Your ref:	Condition Discharge French Do...	Please reply to:	Central Planning Team
Our ref:	24/01009/ADLBC	Tel No:	2514
		Fee Queries:	0207 641 6500;
		Email:	planningreception@westminster.gov.uk;
Mr Jaime Soto Miranda Izzi Renovations Ltd 213 - 215 Gloucester Place Sandfords London NW1 6BU United Kingdom		Incomplete Applications Town Planning & Building Control City of Westminster PO Box 732 Redhill, RH1 9FL	
			22 February 2024

Address: 9 Molyneux Street, London, W1H 5HP,

Proposal: Details of new doors pursuant to Condition 2 (b) of Listed Building Consent dated 08 June 2023 (RN:23/01046/LBC)

GLAZING BAR OPTIONS

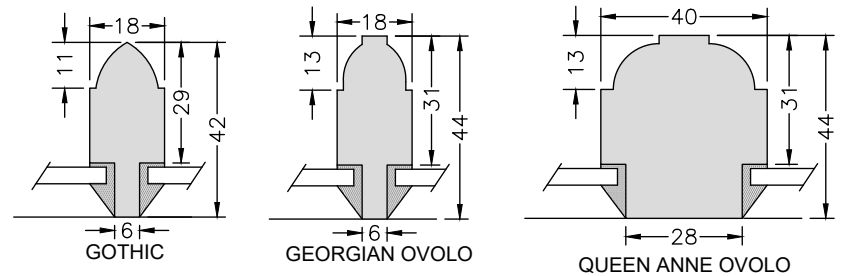
- 1 The details submitted include options for glazing bars. You can not assess options, only one set of details. Please submit a set of details with you preferred option.
- 0 *Please collate all requested information in a single submission and send to planningreception@westminster.gov.uk. Sending your documents individually will not speed up the process. Please do not upload to the planning portal as this causes duplication and may delay the processing of your application. Thank you.*
